From: Contact Centre (CRM) <contact@ribblevalley.gov.uk>
Sent: 21 July 2022 21:26
To: Planning
Subject: Planning Application Comments - 3/2022/0619 FS-Case-438811325

Planning Application Reference No.: 3/2022/0619

Address of Development: Water Tank and Valve House off Vicarage Lane Wilpshire BB1 9HY

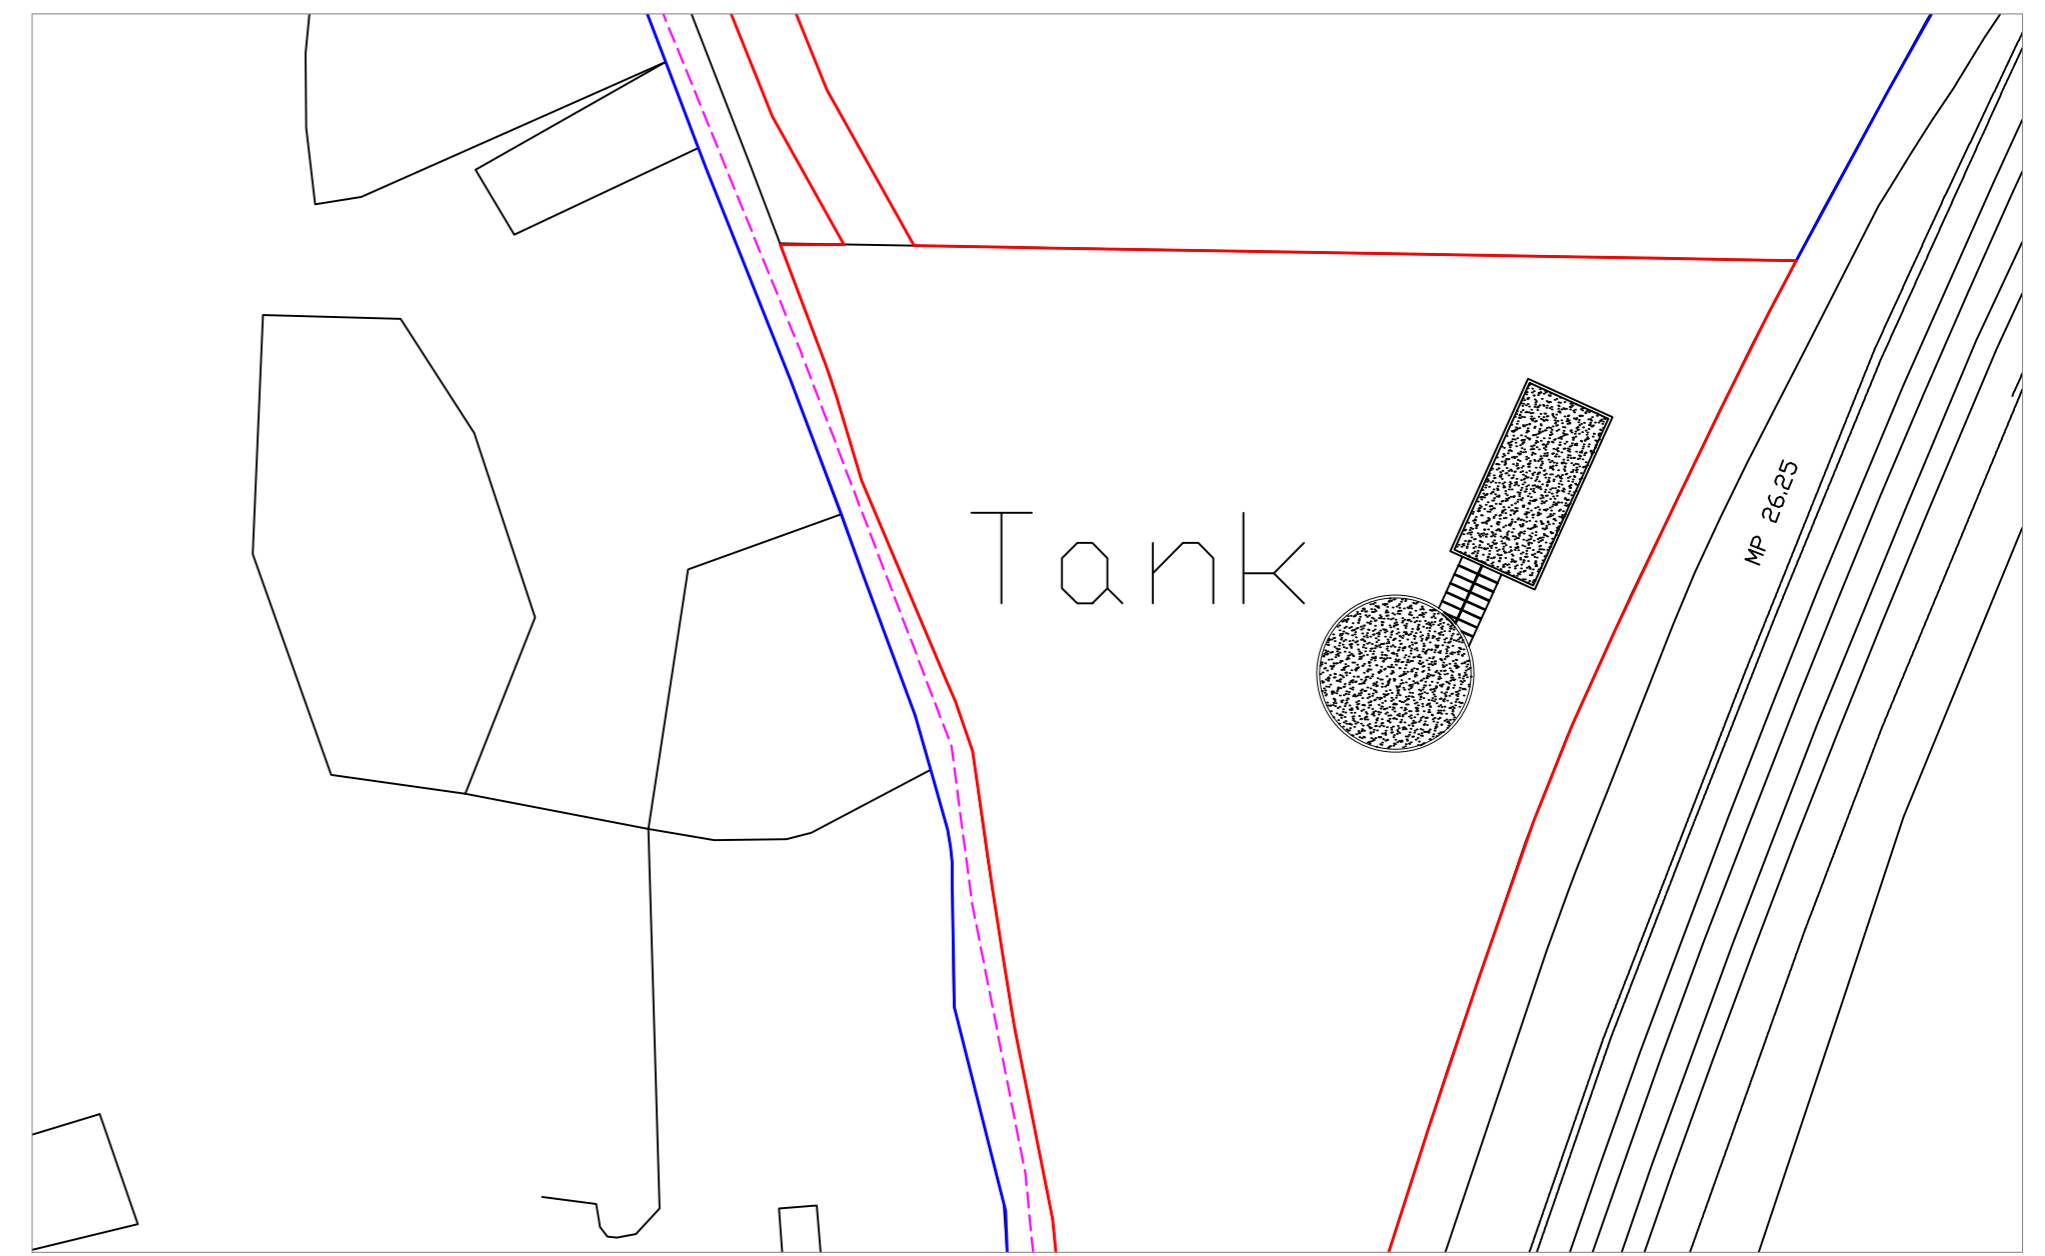
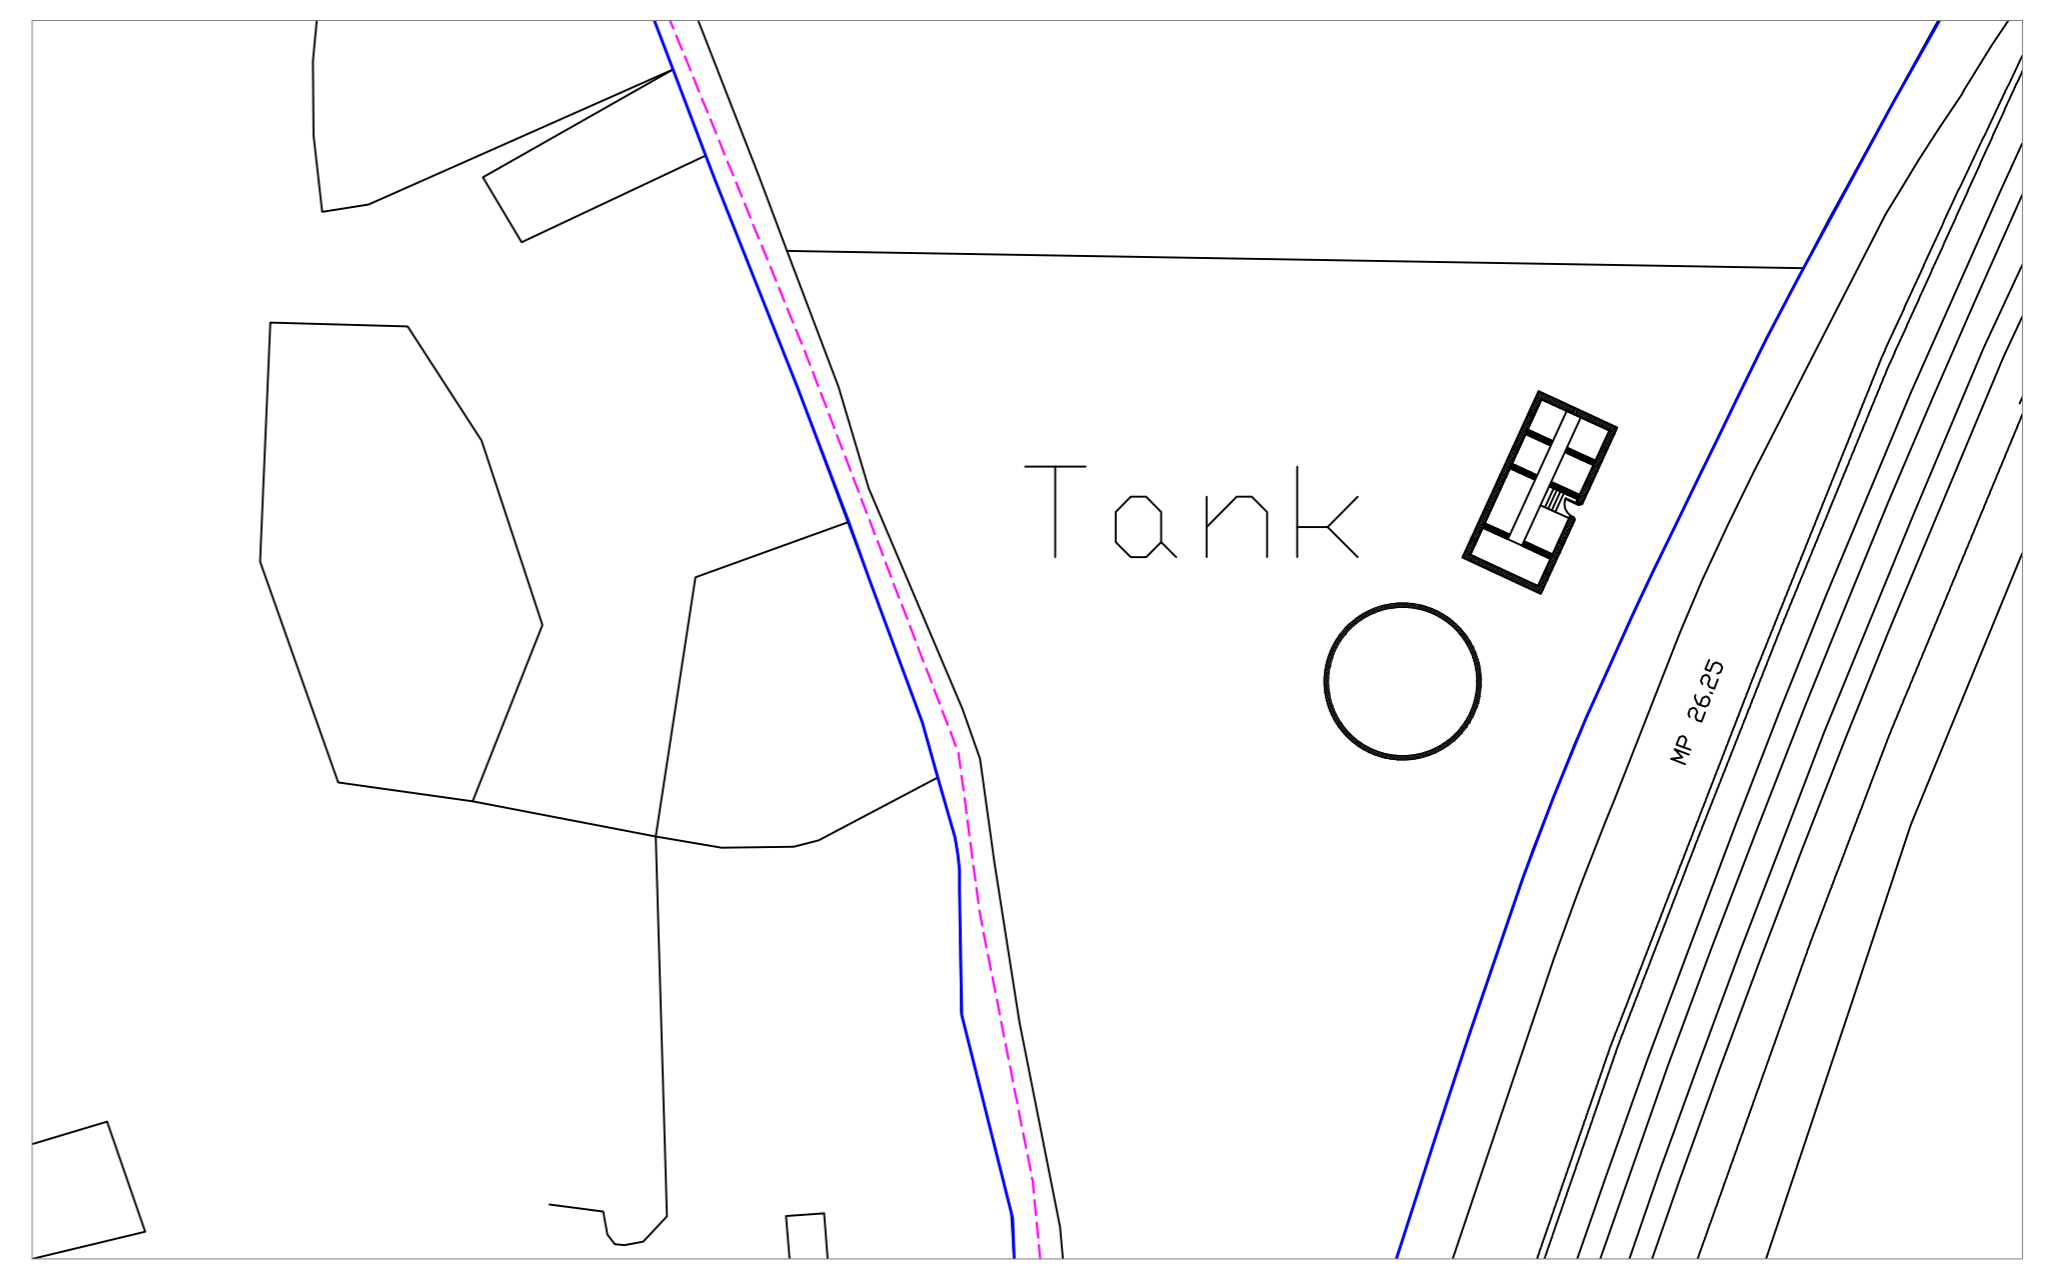
1. The applicant previously made an application for the construction of a track for agricultural purposes - Application No 3/2021/0918. The Planning Authority decided no approval was required based on the information provided. The information provided was incorrect and misleading. This track is now proposed as the vehicular access from Vicarage Lane to the residential development.

2. The proposed development will involve heavy vehicle movements for the supply of materials along Vicarage Lane, a private unadopted road with bridleway status. This road is incapable of withstanding this type of use. Ribble Valley BC has recently abandoned waste collections to the bottom section of Vicarage Lane due to its condition. The construction of the 'agricultural' track from Vicarage Lane involved many tipper truck movements along Vicarage Lane, each of up to 32 tonnes. This caused significant damage to the structure of the Lane for which the applicant provided [REDACTED] I fear this will be repeated and the residents of Vicarage Lane will have to repair the lane at their own expense again. The applicant should reinstate the Lane to a good condition should the development go ahead.

3. If the applicant has a right of way over Vicarage Lane, it is an Agricultural Right of Way. This new use would constitute an Intensification.
4. The application suggests that the foul sewage will be treated using a package sewage treatment plant. There is no indication of where the effluent will ultimately be discharged. There are no suitable watercourses nearby. Where will the effluent be discharged?
